**From:** isobel.hartley@historicengland.org.uk  
**Sent:** 28 March 2025 11:53  
**To:** \_planningadvice  
**Subject:** Historic England advice on Application no(s) H16-0209-25  
**Attachments:** H16-0209-25\_HERef\_L01589581\_L467736.doc

The Sessions House, Sheep Market, Spalding, Lincolnshire, PE11 1BB  
Application No(s):H16-0209-25

### **Arrangements for Handling Heritage Applications Direction 2021**

**Application No. H16-0209-25**

PROJECT TITLE Proposed Removal of Tiered Viewing Gallery	CLIENT Castle Events Ltd, The Sessions House, Sheep Market, Spalding	CHK BY ---	DRAWN BY CLA
DRAWING STAGE Planning	SCALE 1:50 @ A1	STAGE PLN	REV D
SHEET TITLE Removal Plan	PROJECT NUMBER PE11-4138	SHT 002

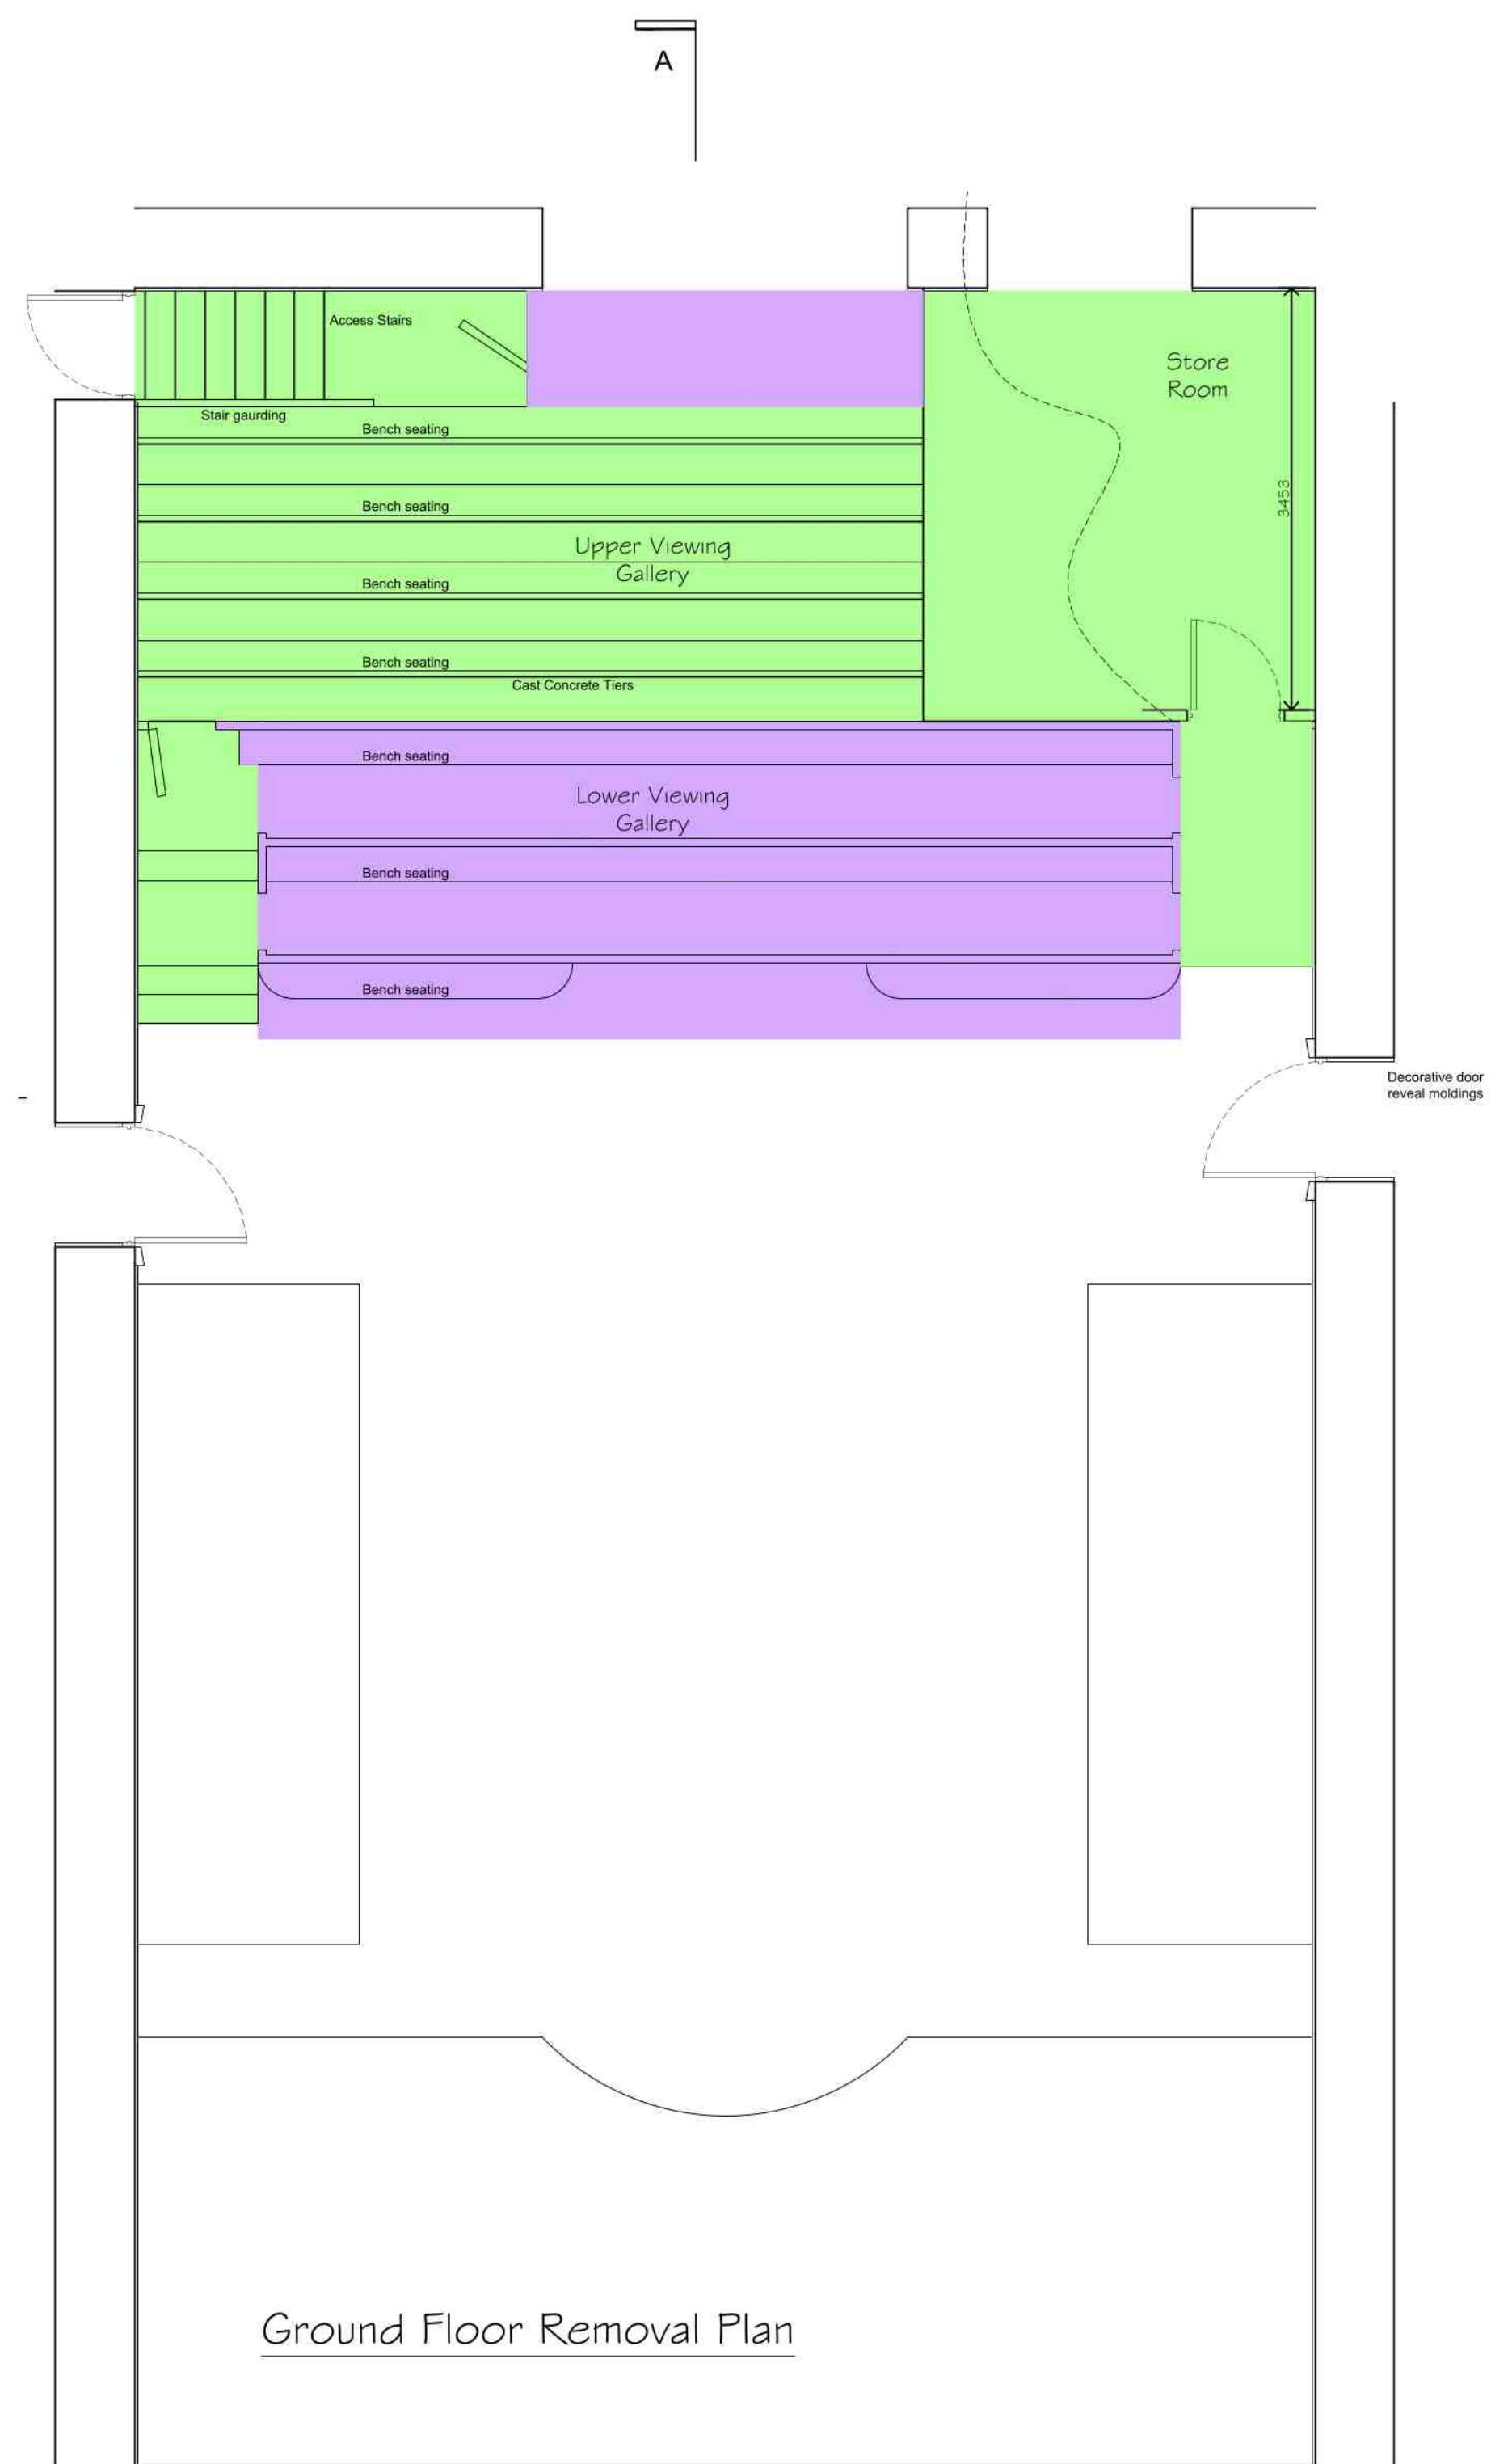
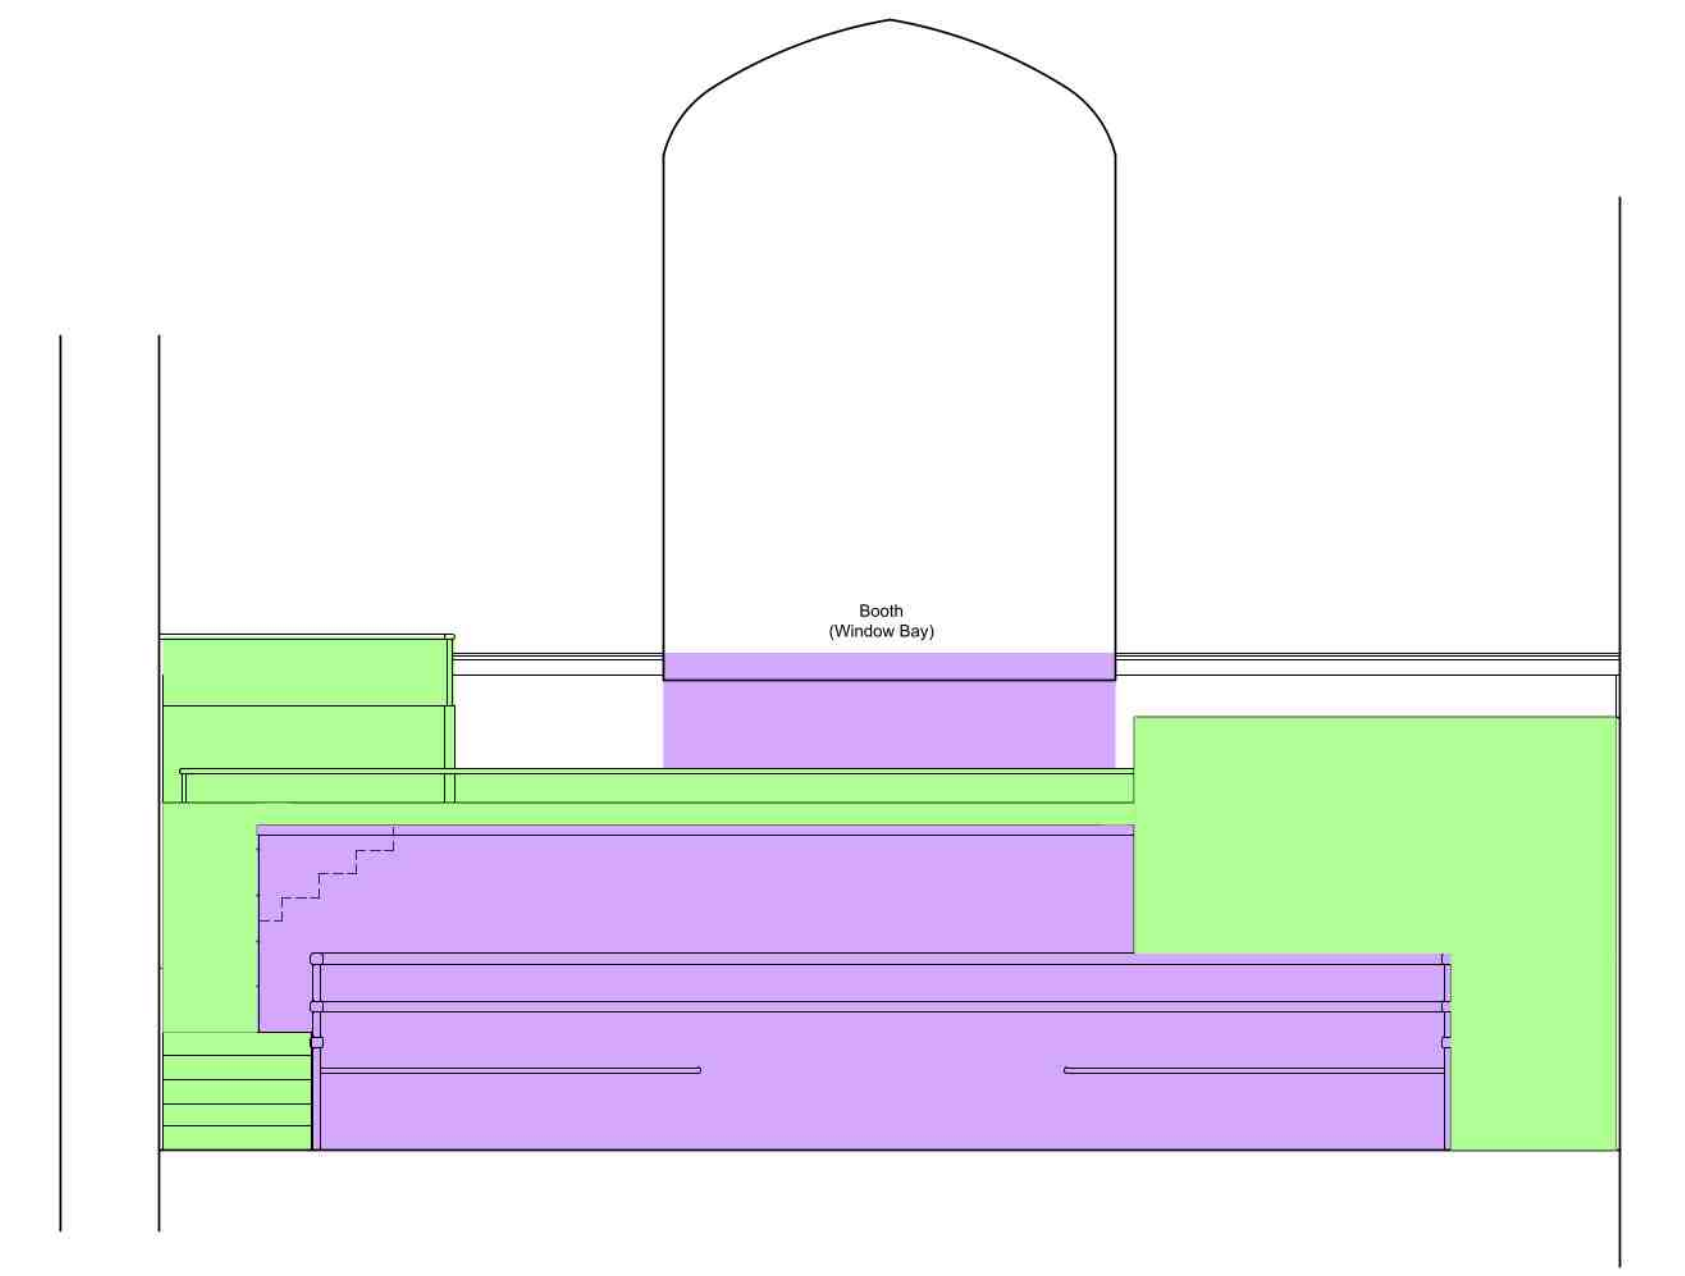
We do not object to the removal of some of the benches within the viewing gallery, however we do have concerns with the removal of all benches as currently proposed.

Historic England do not consider that the original, fixed, wooden benches in the Viewing Gallery are secondary to the primary architectural and historical features of the space, as stated in the Heritage Statement. We consider that they represent a principal feature and contribute considerably to significance.

The benches are intrinsic to understanding the room's previous purpose, therefore the total removal of all benches in the Viewing Gallery would be harmful to the building's overall heritage significance.

We encourage the exploration of other configurations which would include the retention of some of the fixed benches.

Should the applicant wish to pursue the total removal of all benches as proposed, we recommend amendments to include robust justification for the requirement of this space in particular, such as an options assessment and evaluation of alternative available spaces within the building.

Information should also be provided to your Conservation Officer about the proposed removal method and storage of historic fabric.
